Office of
Environment
& Heritage

DOC18/253820
SSD-8669

St Aloysius' College Redevelopment – 47 Upper Pitt Street, Kirribilli (SSD 8669)

Attachment A

ROOF LEVEL PROPOSED SHADE AMENITY

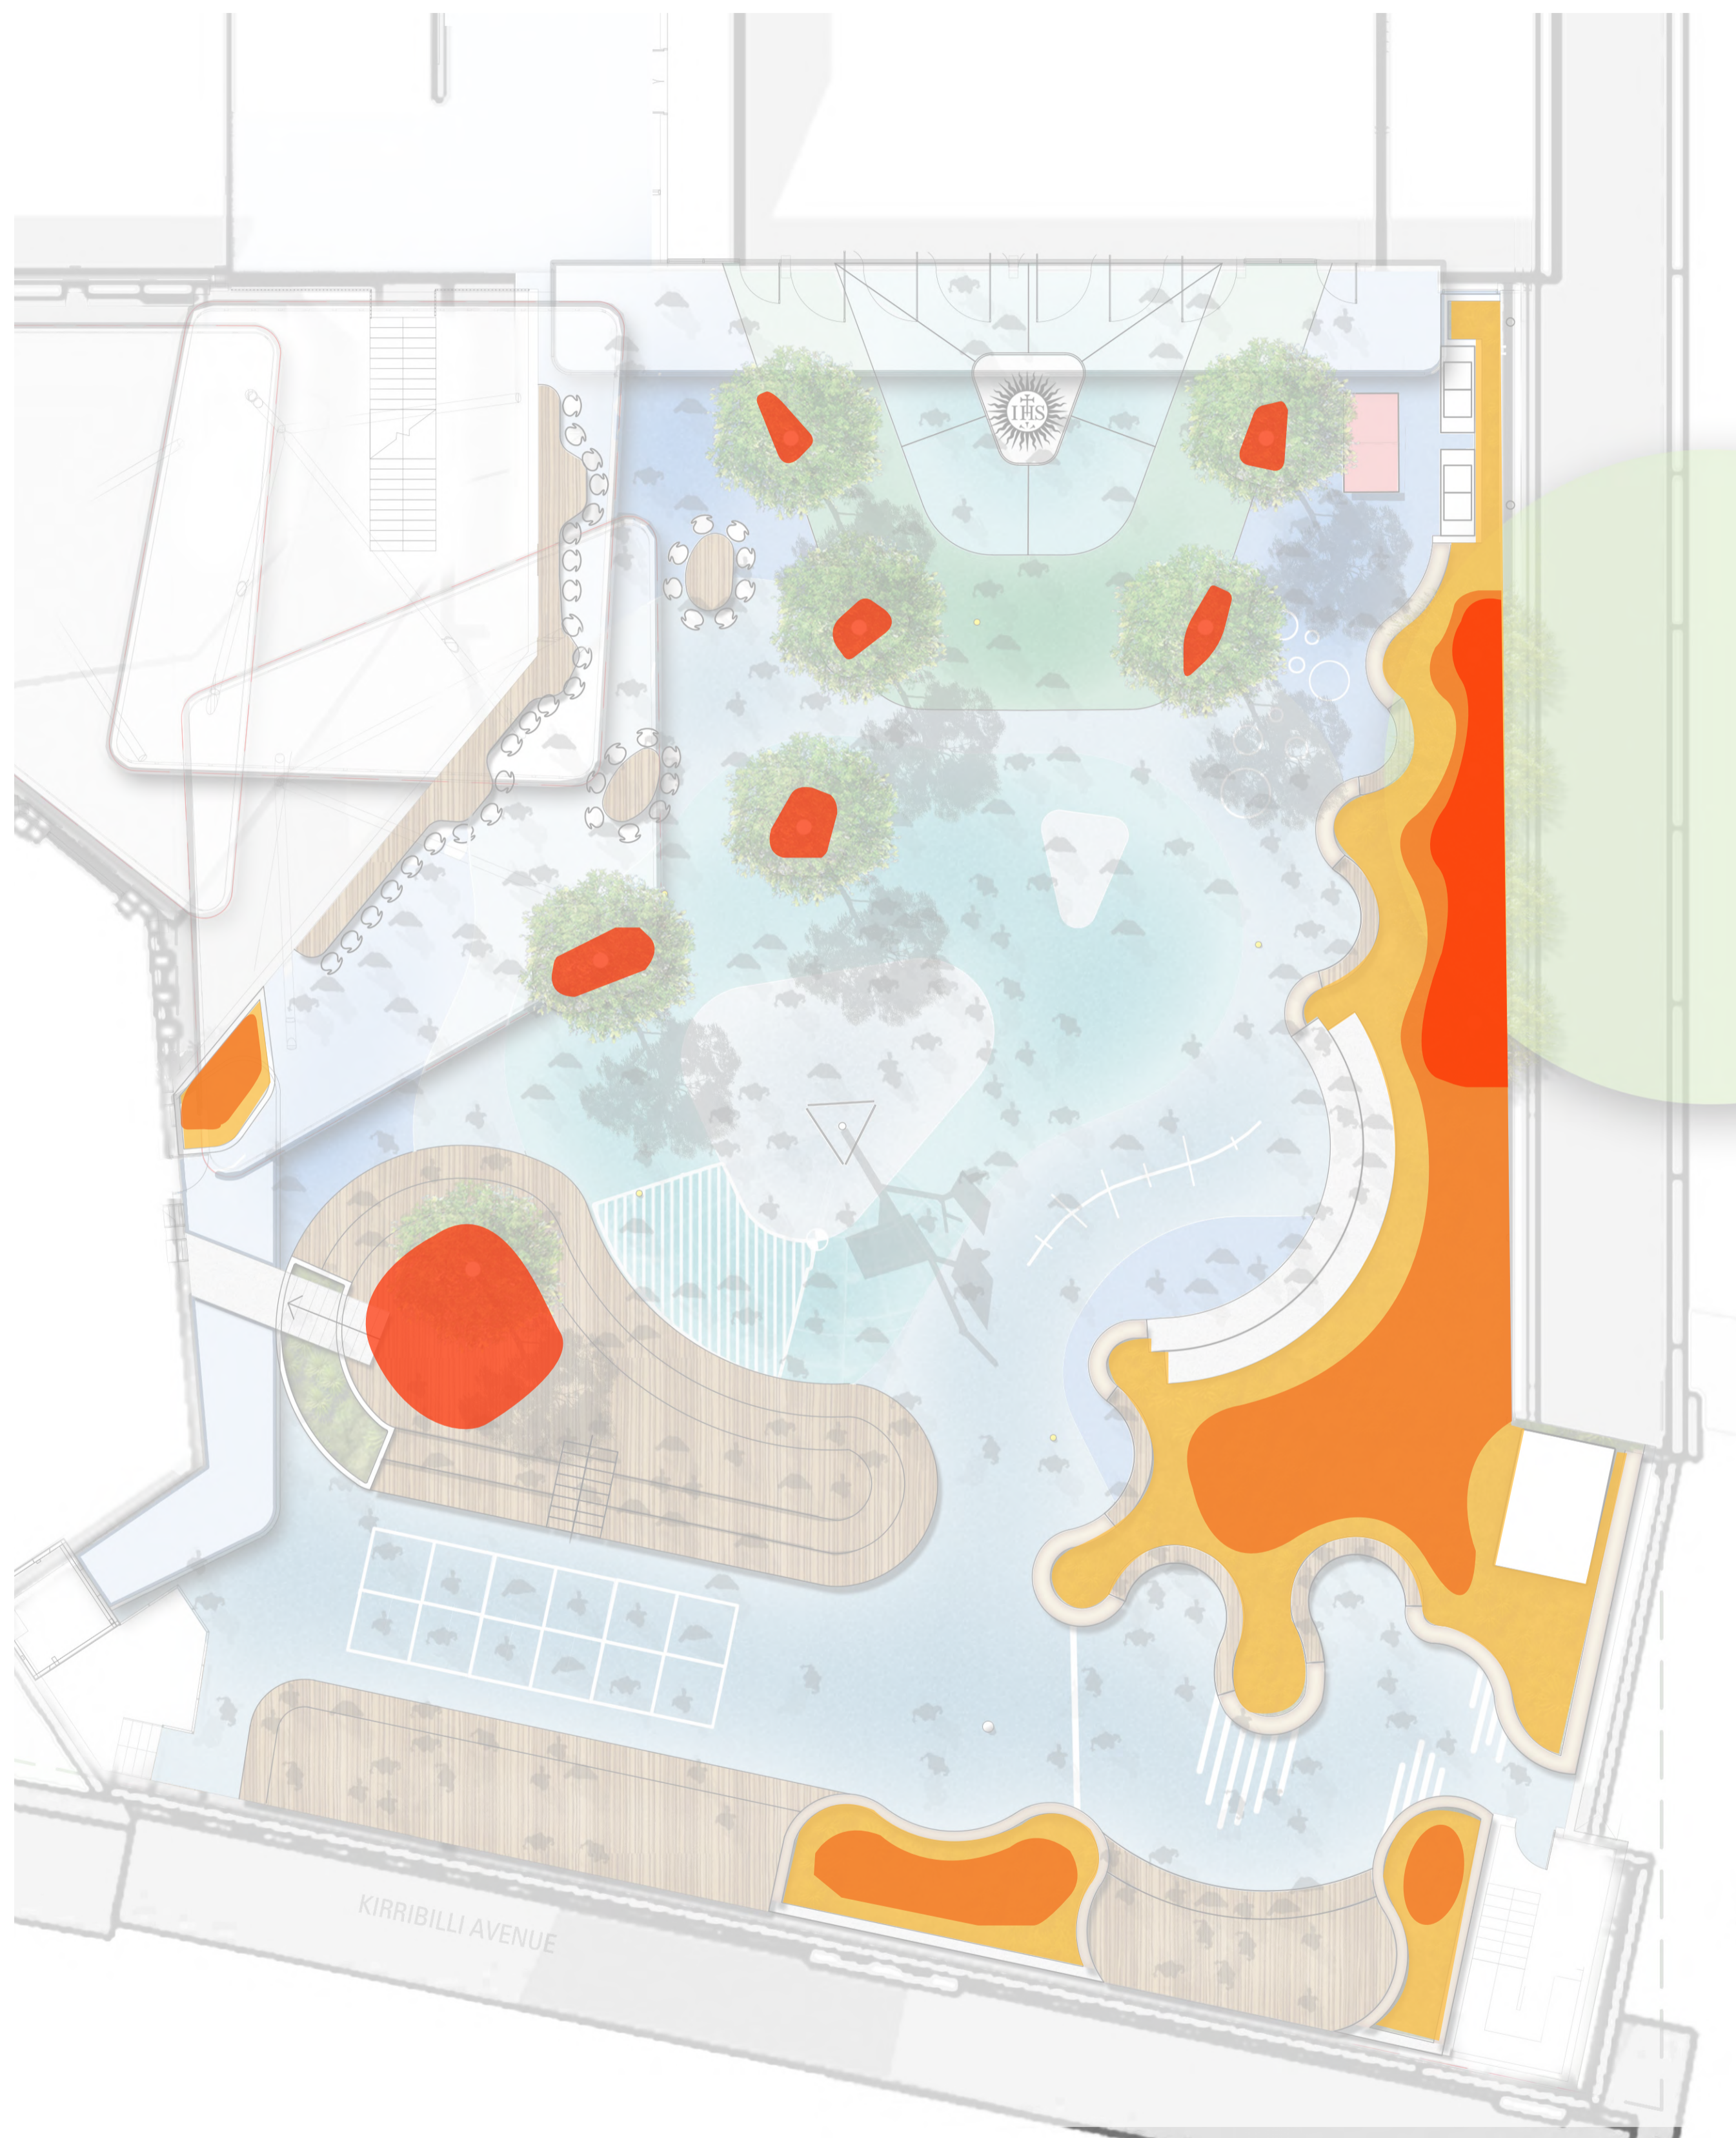
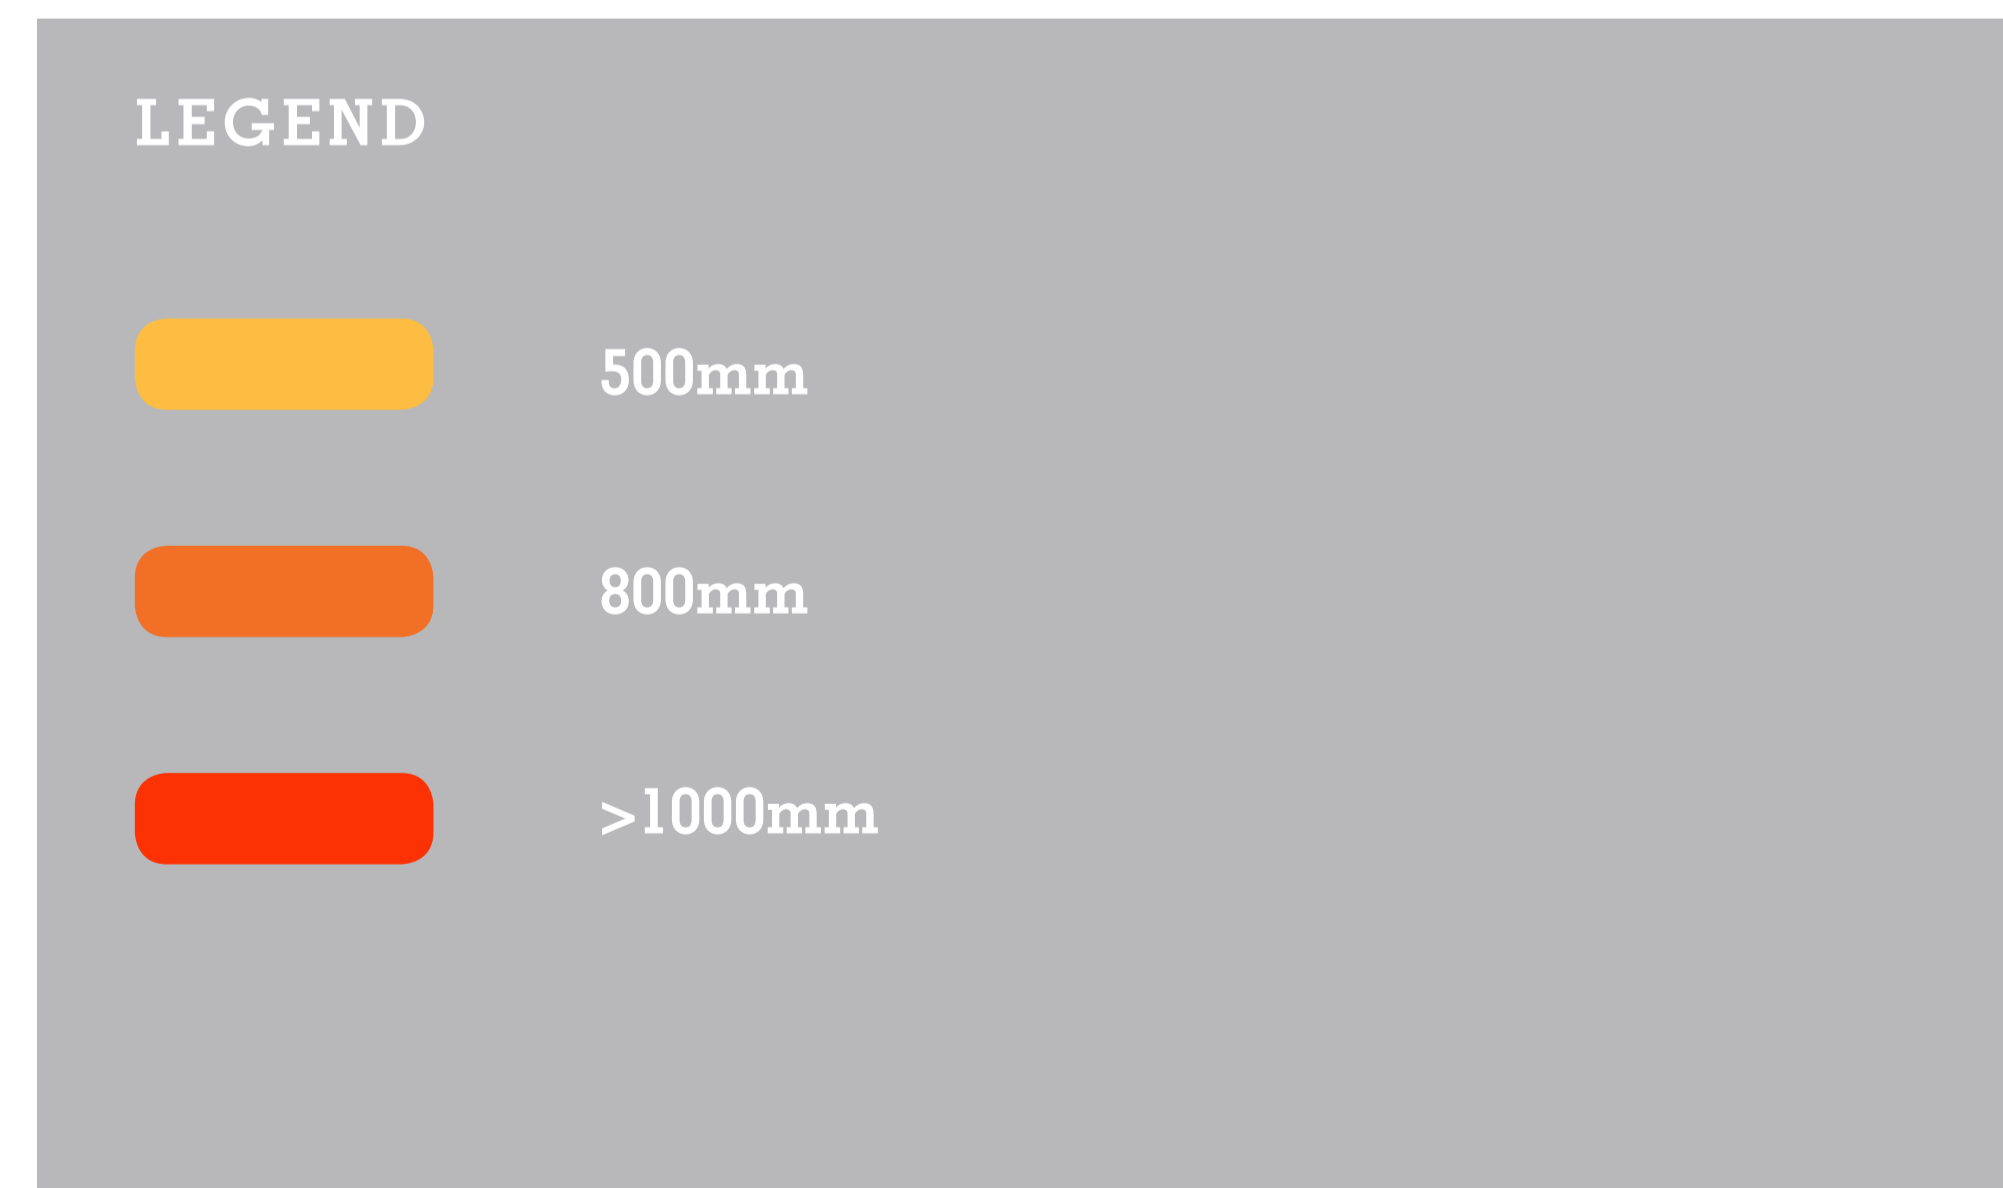
The EIS indicates the Concept Plan for the Main Campus includes a rooftop terrace (page 39) which includes a mixture of green roof and hard paved surfaces (page 56). OEH supports the development incorporating a Green Roof and/or a Cool Roof into the design. The benefits of Green Roofs and Cool Roofs are outlined in the OEH (2015) Urban Green Cover in NSW Technical Guidelines which can be found at the following link:

Green roofs are roof surfaces that are partially or fully vegetated. Cool roofs use reflective material to reflect and emit more solar energy than dark coloured roofs.

Green roofs and cool roofs can have a strong regulating effect on the temperature of roofs and building interiors, reducing the energy needed for cooling and the impact of the Urban Heat Island effect. The provision of an Intensive Green roof would increase habitat and biodiversity at the site, particularly if local native plant species are used from the relevant native vegetation community.
